# DESIGN PROFESSIONAL INSPECTION FORM

Residential Single Family Project: Y	Commercial Project: N
Code Enforcement Project No:	Permit No: SFD2103-0074
Project Name:	Owner: Ryan Homes
Project Address: Lot 96 Quail Glen – 11 Bird Dog Dr. (Angier, NC)	Suite No:
Date Inspected: 06/09/2021	Contractor Name: Ryan Homes
Component Inspected: Mono-Slab

Describe Element/Component: \* 3rd Party Monolithic Slab Inspection

FOUNDATION PLAN
SCALE: 1/4" = 1'-0"

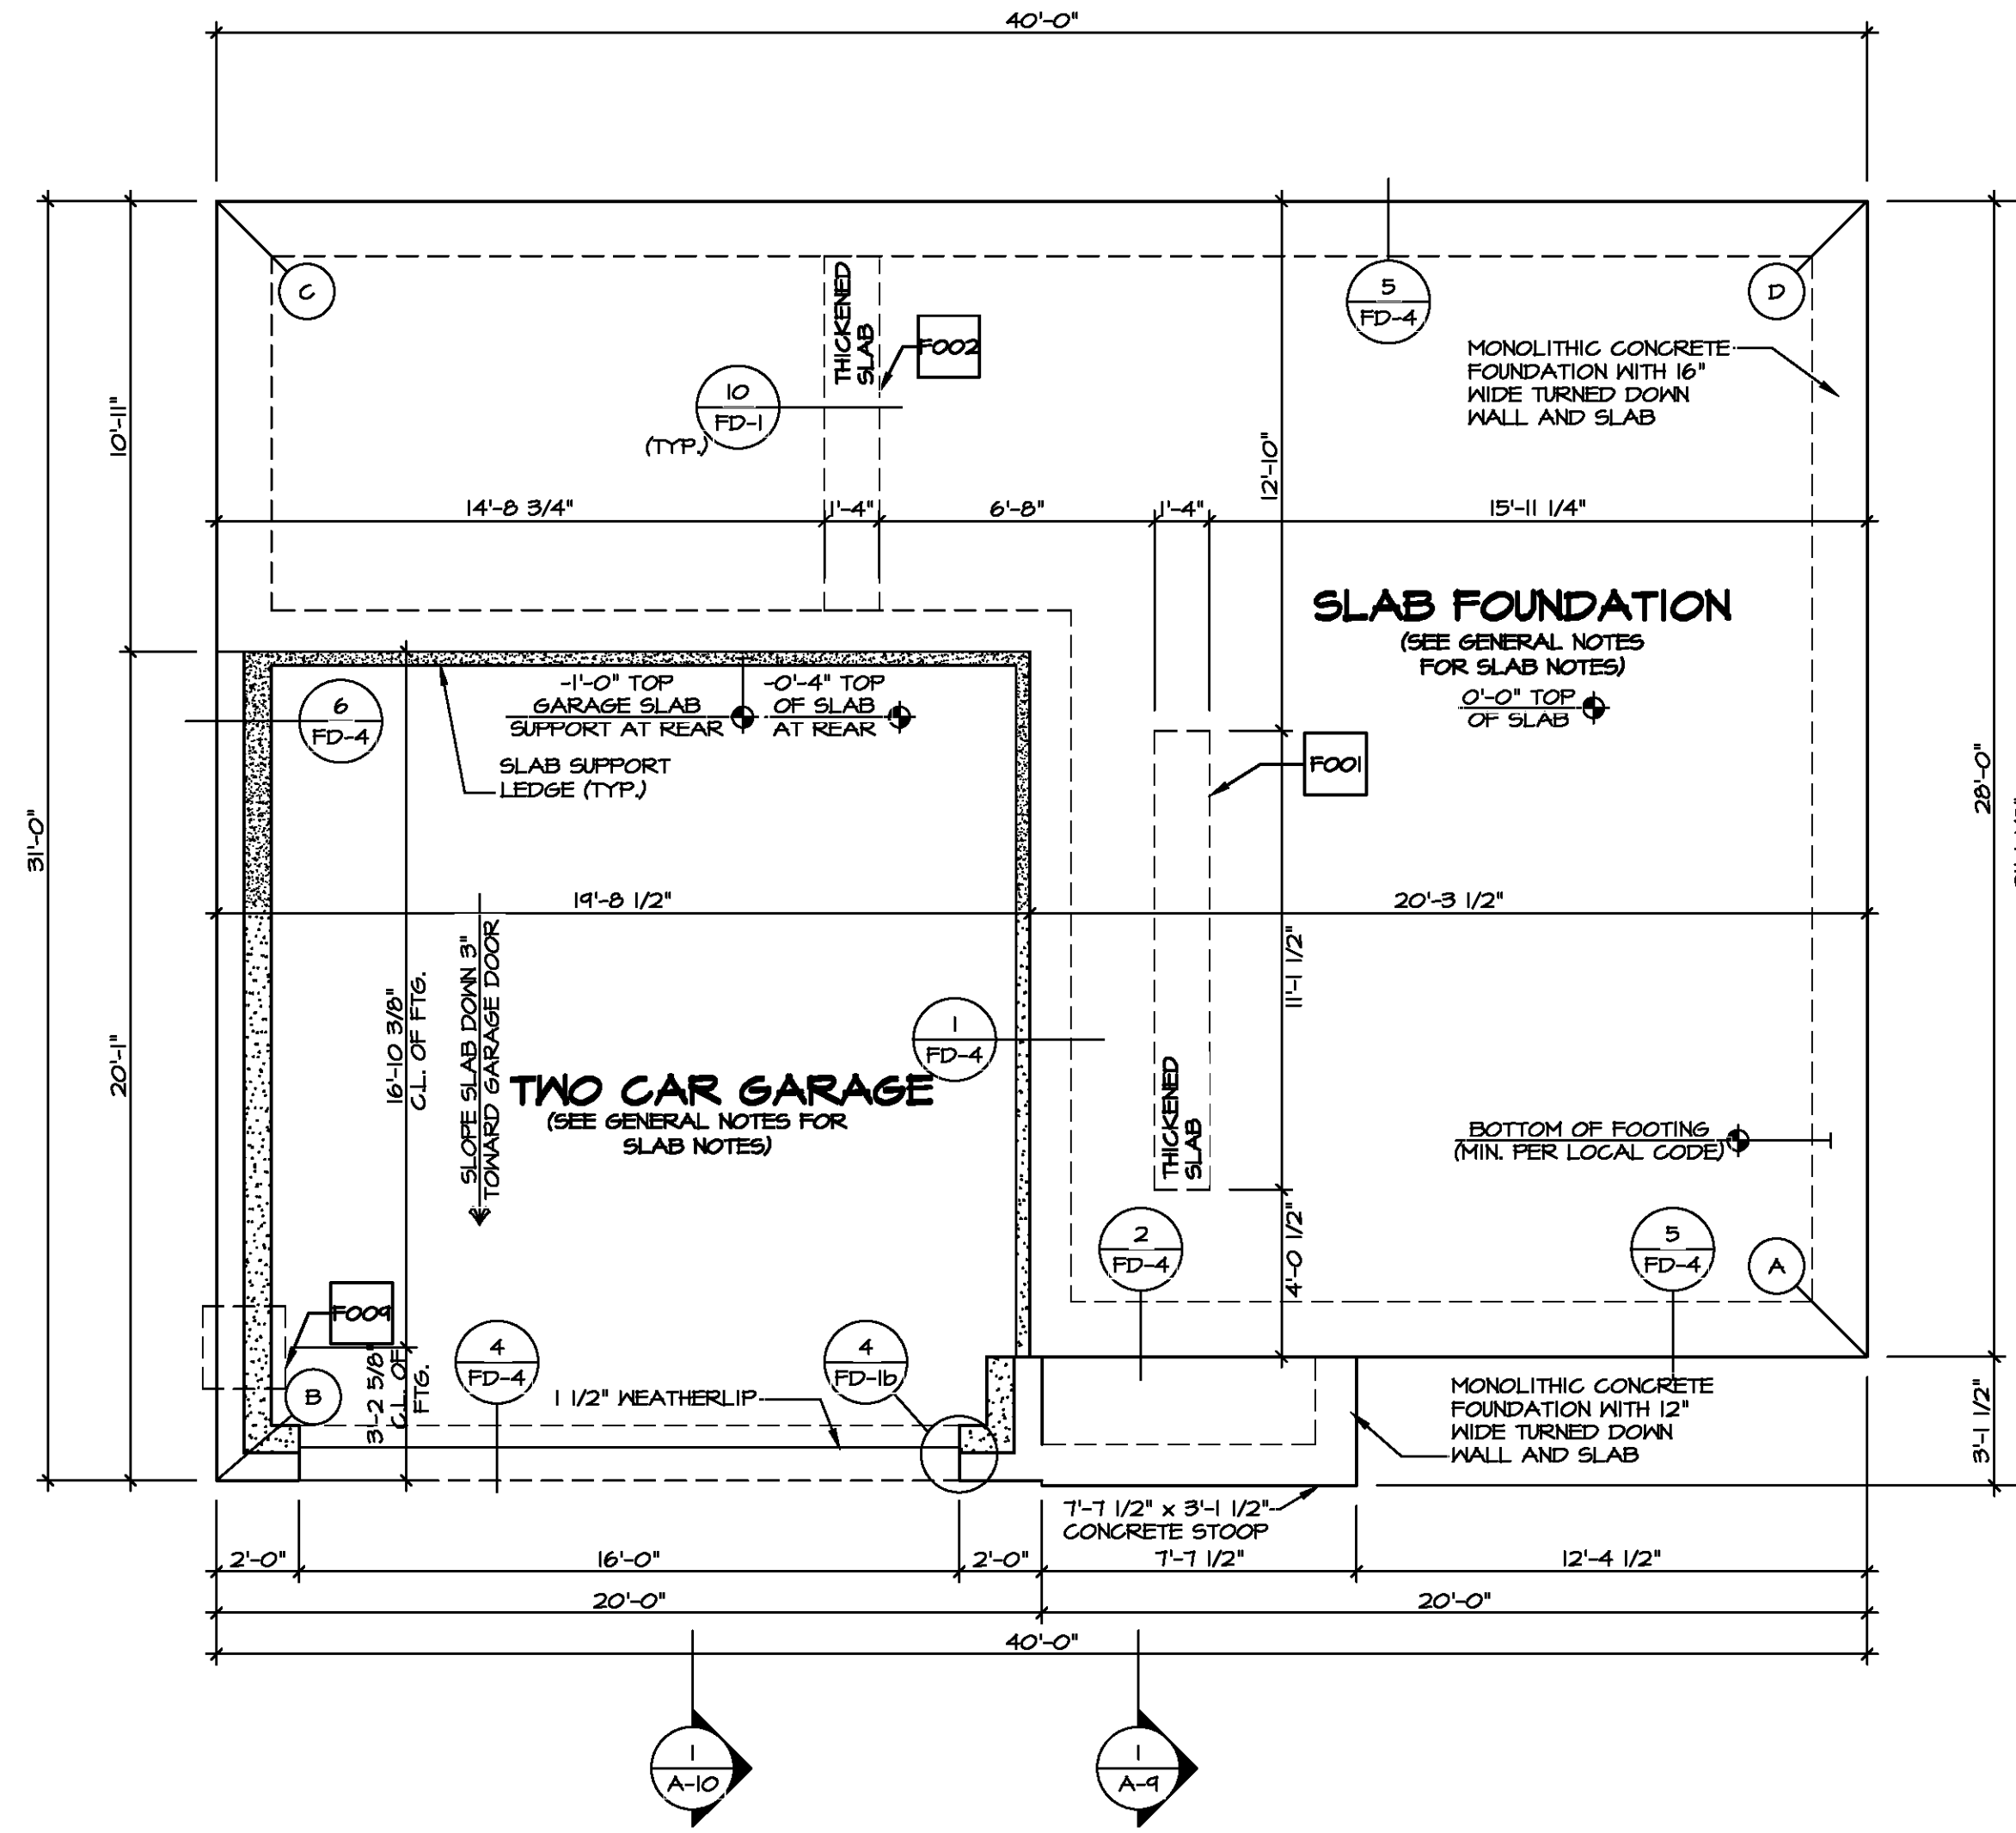
Note: An ERI may be required for final inspection due to missing perimeter insulation at the right and rear of the garage.
